**NORTH
NORFOLK
DISTRICT
COUNCIL**

Norfolk Vanguard Offshore Wind Farm

REPRESENTATIONS FOLLOWING ISSUE SPECIFIC HEARINGS ON 24 & 25 APRIL 2019

DEADLINE 7 – 02 MAY 2019

Figure: 25.2		Drawing No: PB4476-005-025-002			
Revision:	Date:	Drawn:	Checked:	Size:	Scale:
04	22/05/2018	NJ	MS	A3	1:25,000
03	26/04/2018	AB	MS	A3	1:25,000

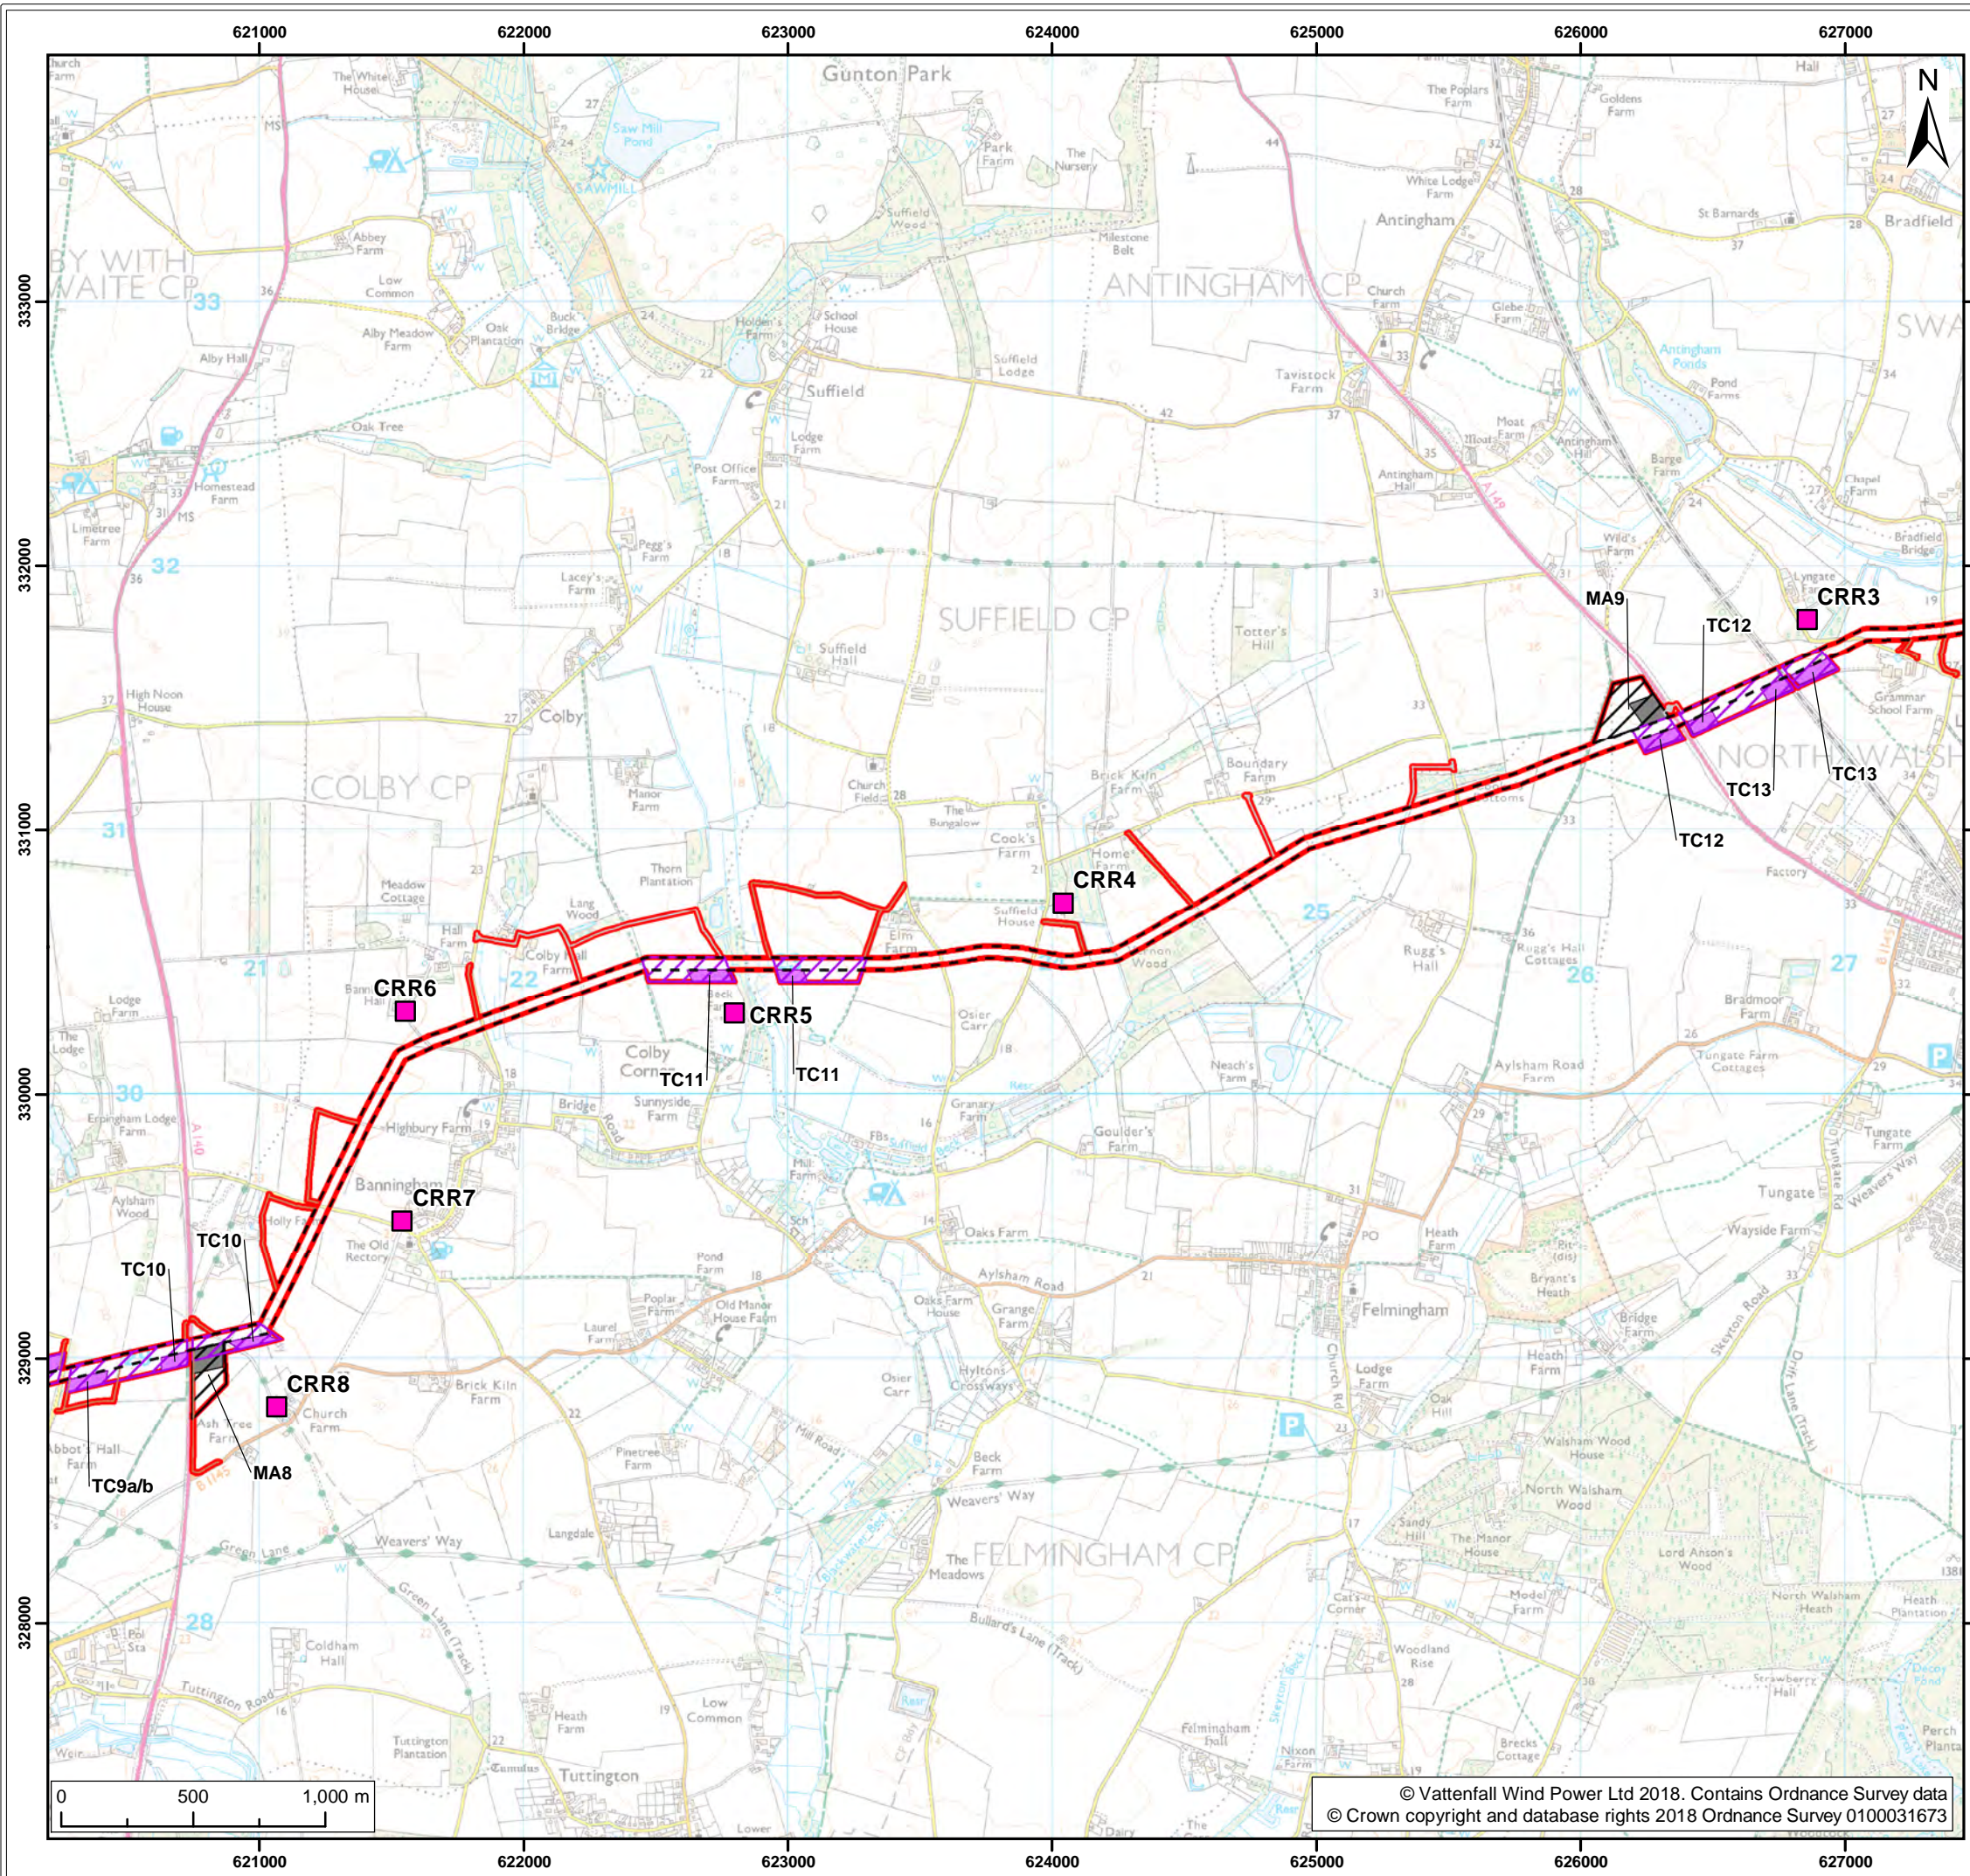
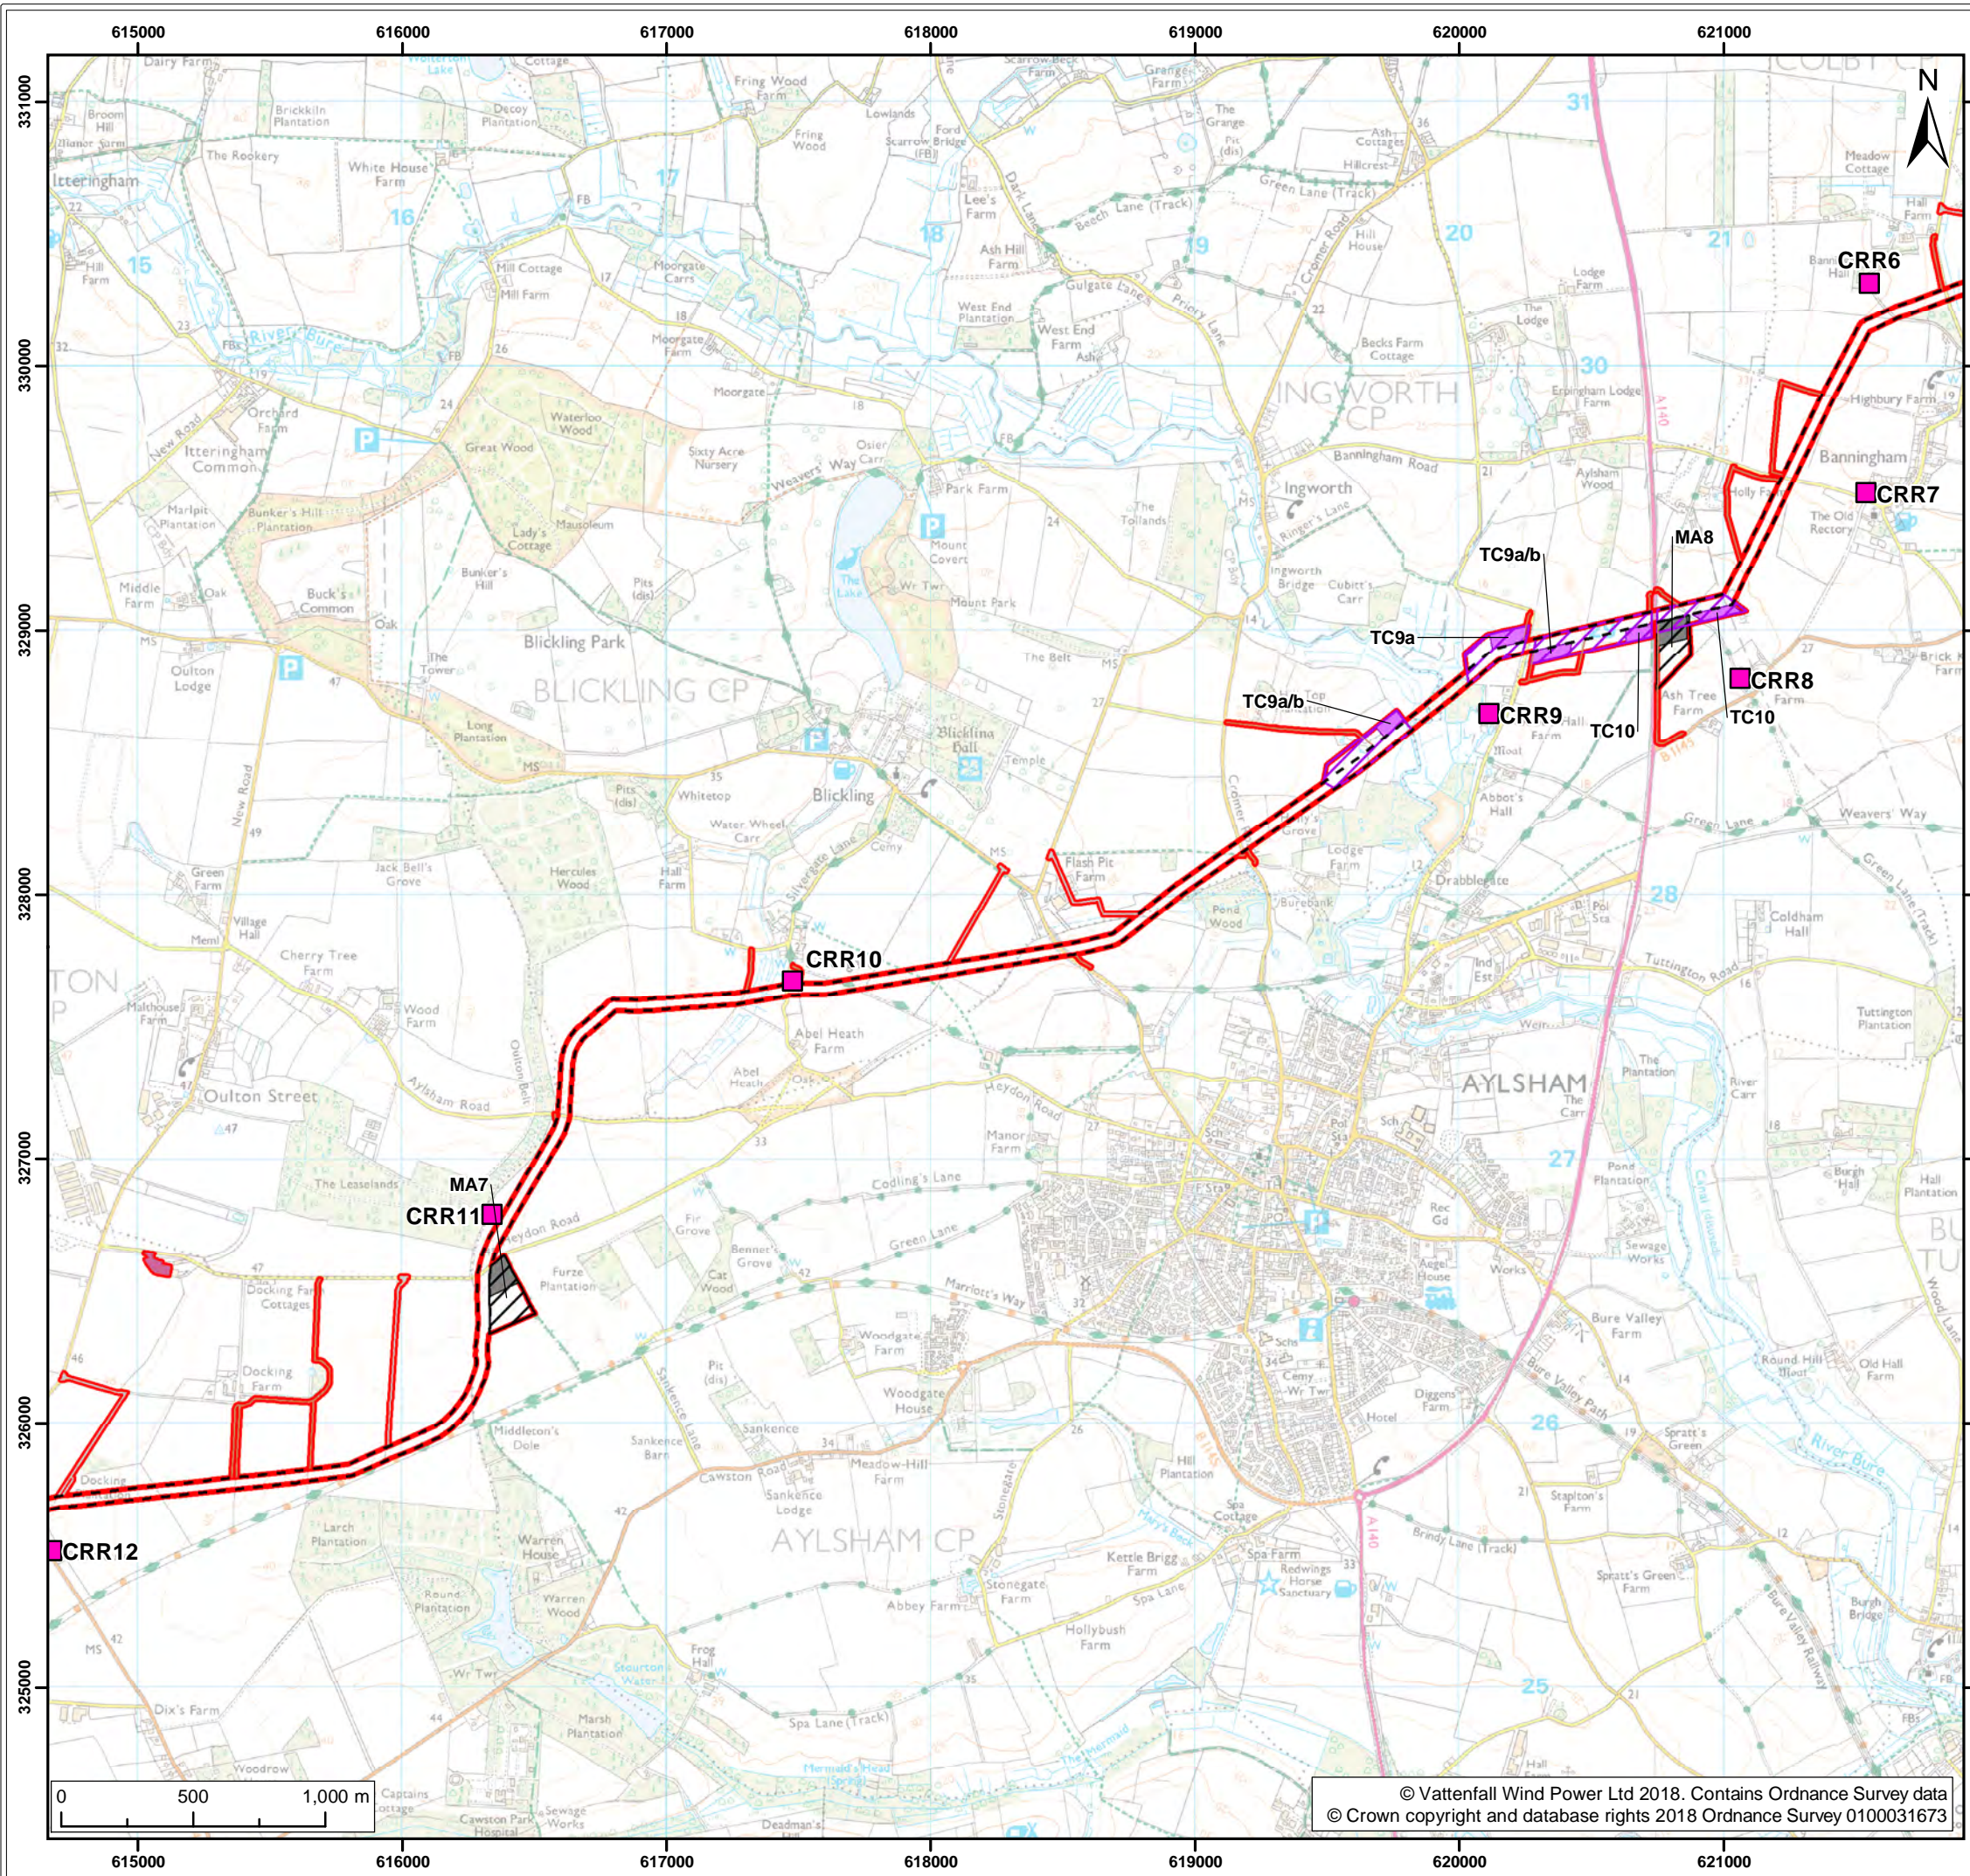
- 4.9. The Construction Noise Impact Assessment provided by the Applicant has highlighted other issues including exceedance of daytime noise thresholds at two locations in North Norfolk (based on Environmental Statement Figure 25.2 – Noise Receptor Locations – Map 1 (APP-590):
- CRR1E; and
 - CRR3F

- 4.10. The Applicant has suggested some additional mitigation to address the noise exceedance including provision of temporary barriers. NNDC would expect these additional measures to be captured within the updated Outline Code of Construction Practice and would welcome further discussion to ensure any mitigation is acceptable.
